Date: 18-May-2026
Our Ref: 2025/90459

**Discharge of details reserved by condition 4 (drainage) of previous permission
2022/90464 for use of land for car wash and access works to create one-way system
Private Car Park, Sheepridge Road, Sheepridge, Huddersfield, HD2 1HG
Application Number: 2025/90459**

Condition 4

DRAWING STATUS:		A - FIT FOR CONSTRUCTION	
kita. ENGINEERING			
SITE/PROJECT:			
SHEEPRIDGE ROAD			
TITLE:			
STANDARD DETAILS SHEET 2 OF 2			
SCALE @ AT:	DESIGNED:	DRAWN:	DATE:
As Shown	OK	OK	January 2025
DRAWING No:			REV:
SHRP-00-CV-SD-0101			C01

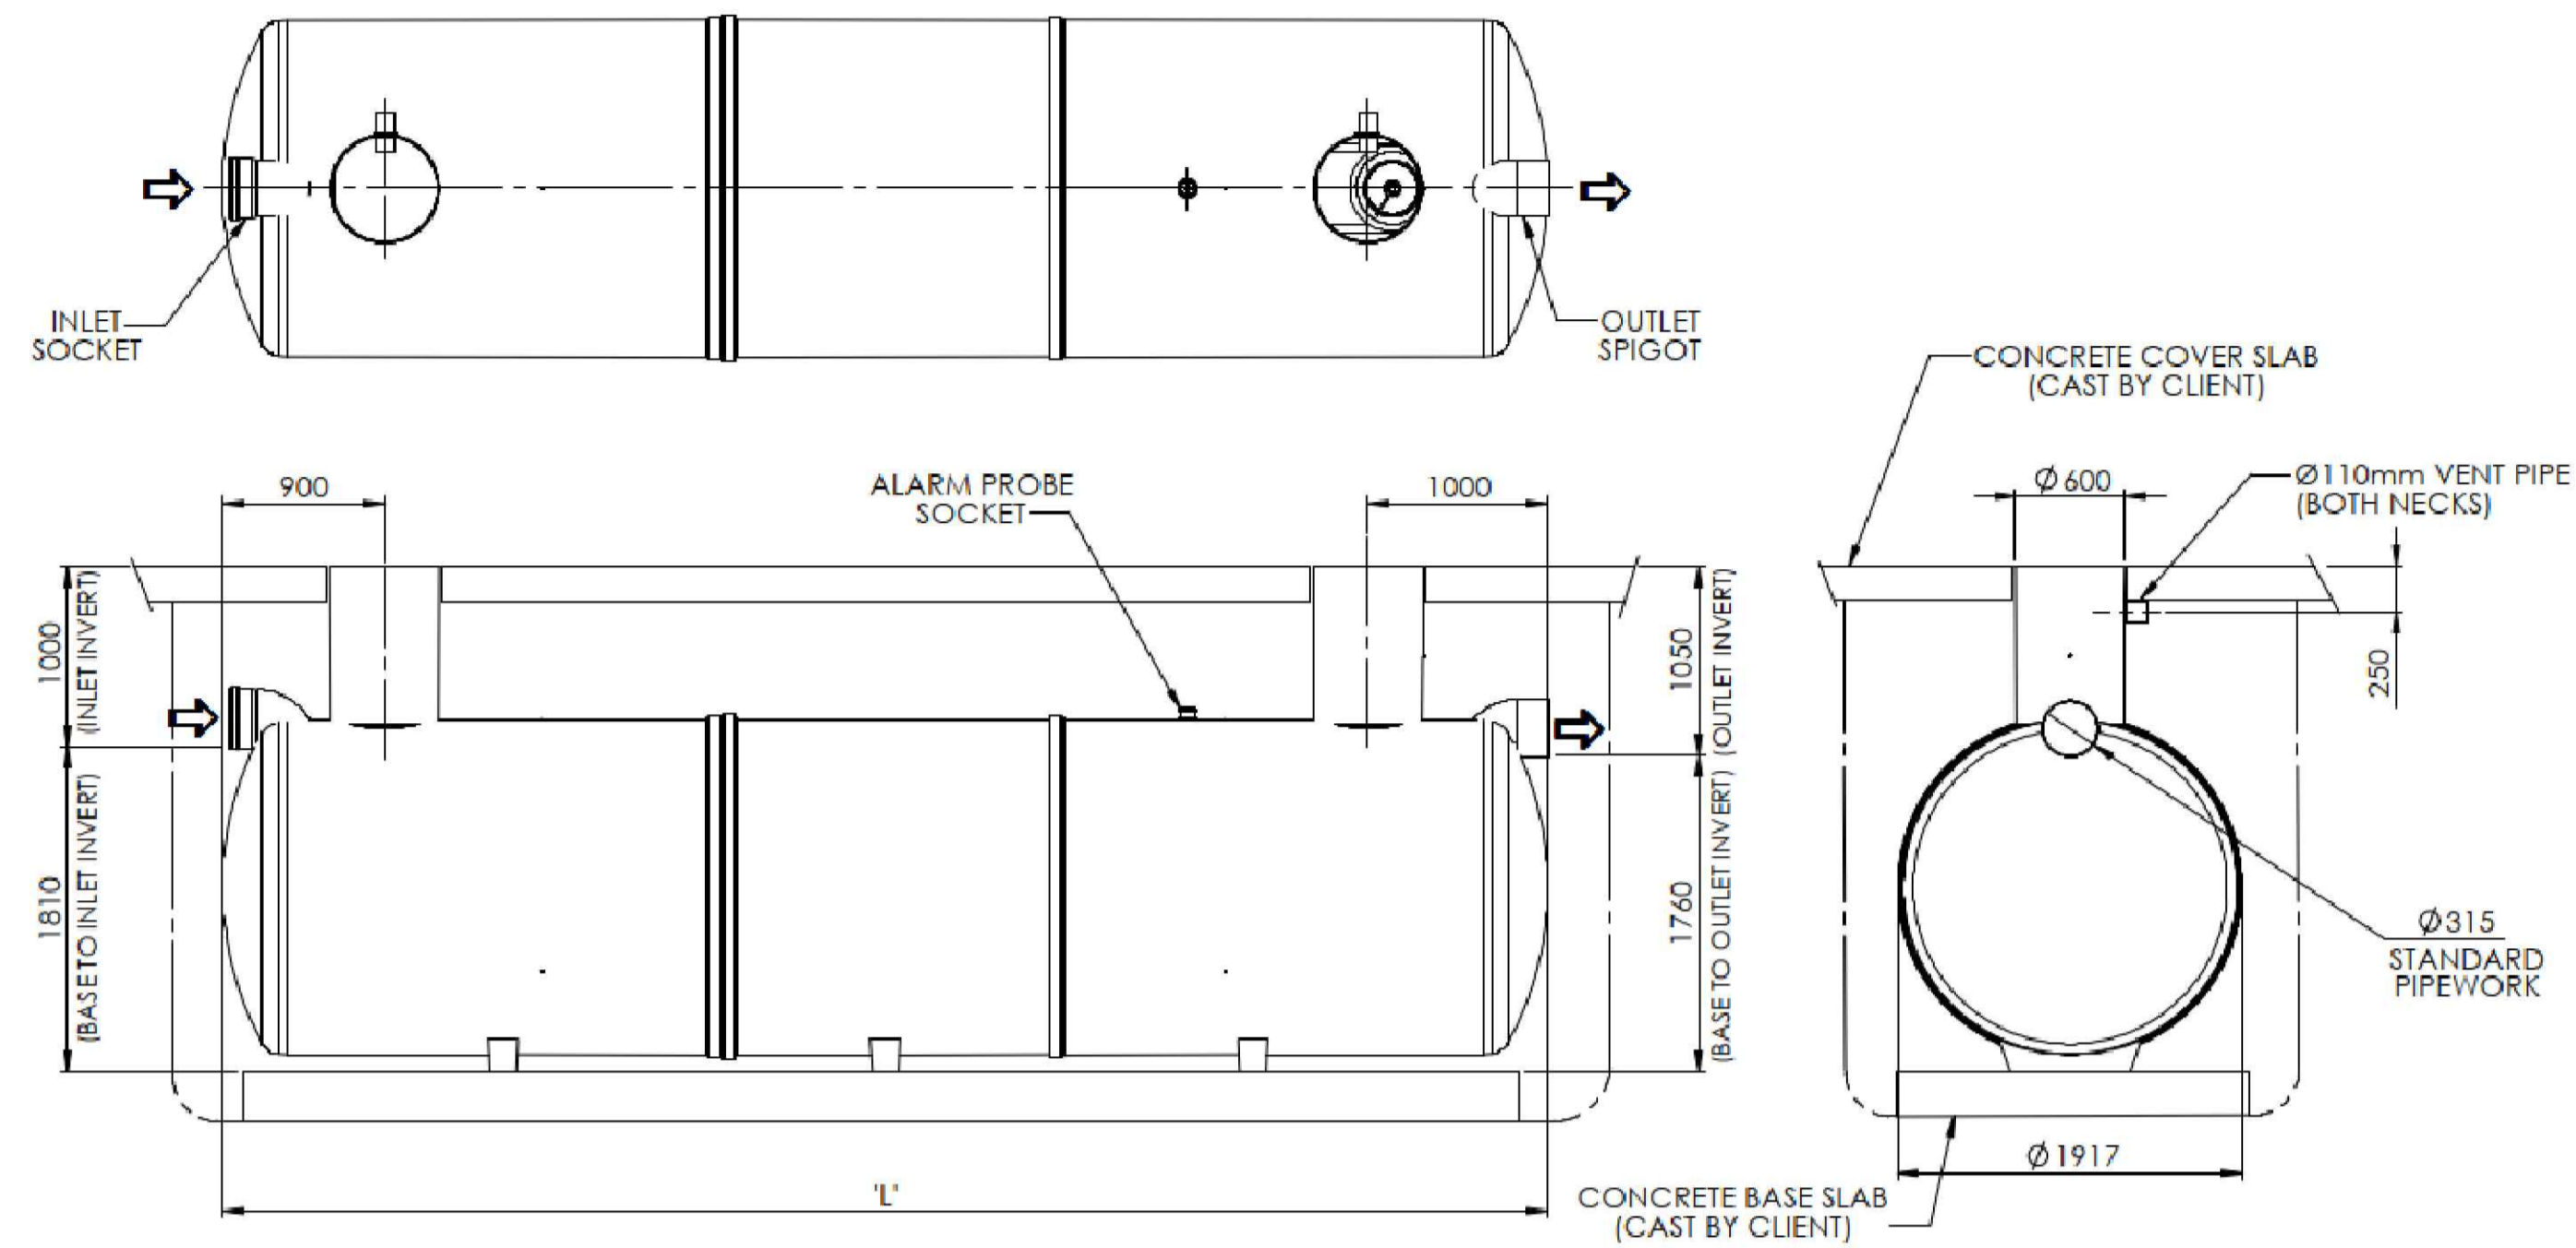
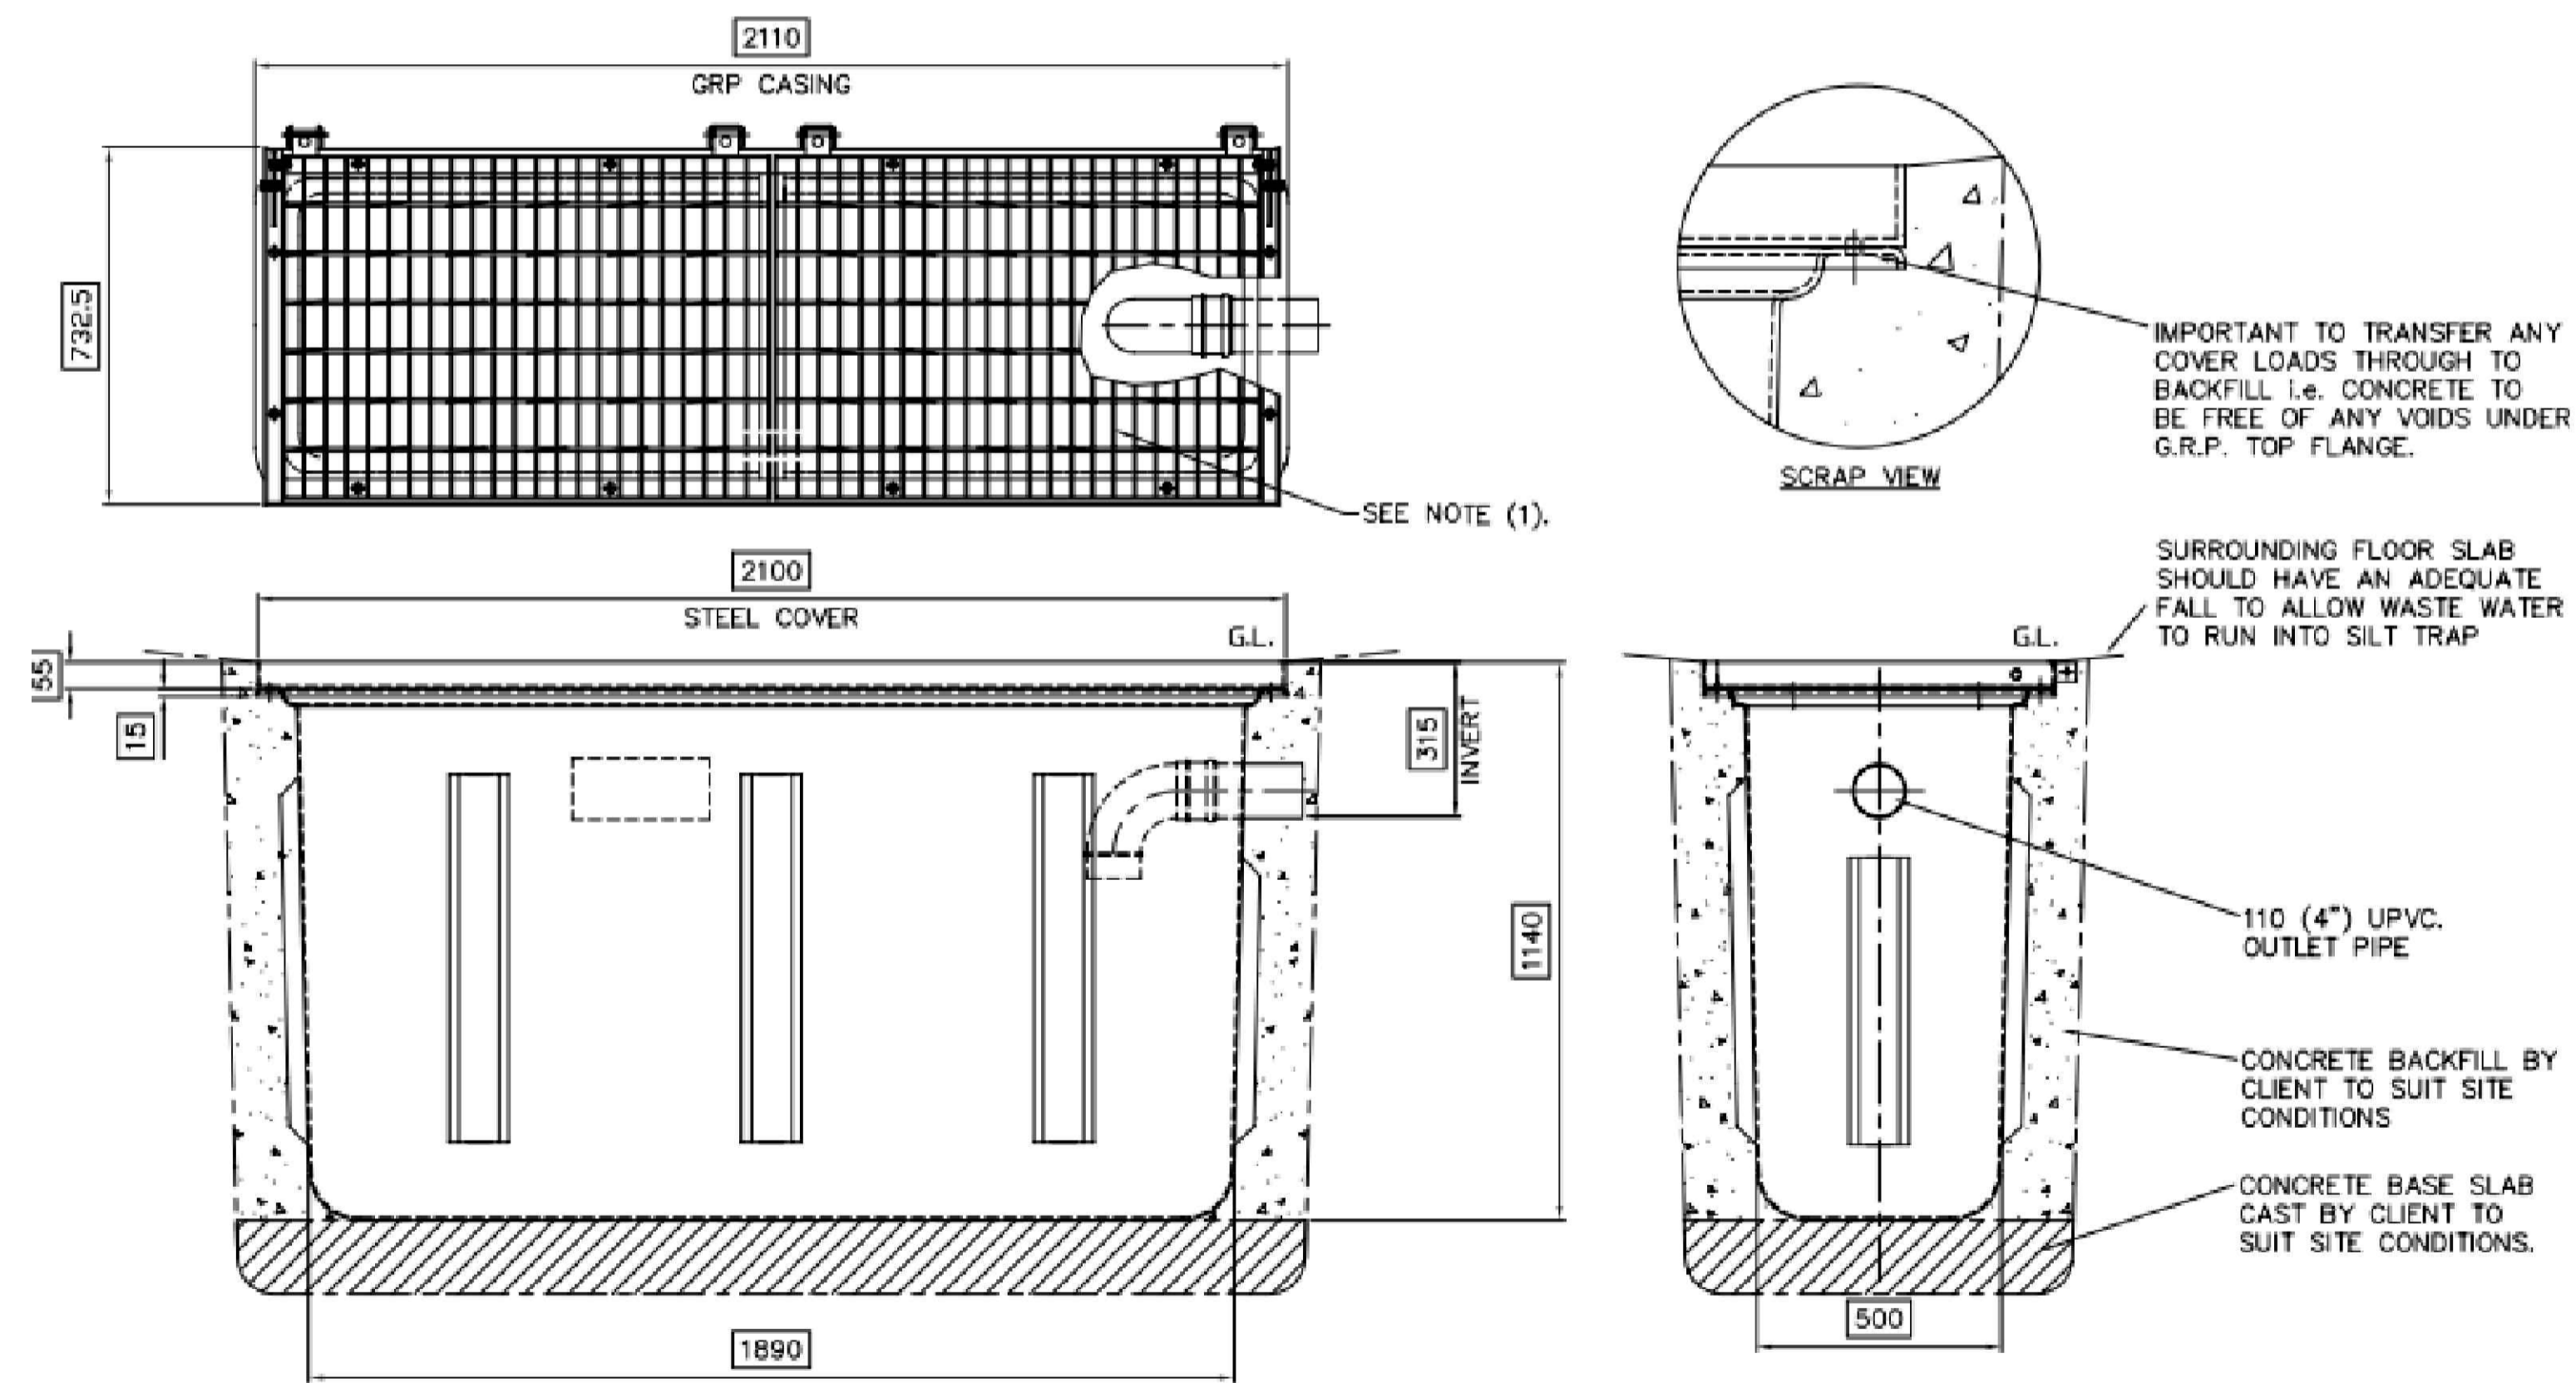
Insufficient drainage details have been submitted to demonstrate a compliant surface water drainage strategy, including the treatment of contaminated run-off and the provision and location of appropriate interceptors, contrary to Policy LP32 and Yorkshire Water requirements. Accordingly, the Local Planning Authority cannot be satisfied that the development would adequately prevent pollutants entering the public sewer network or nearby watercourses. Therefore, Condition 4 cannot be discharged.
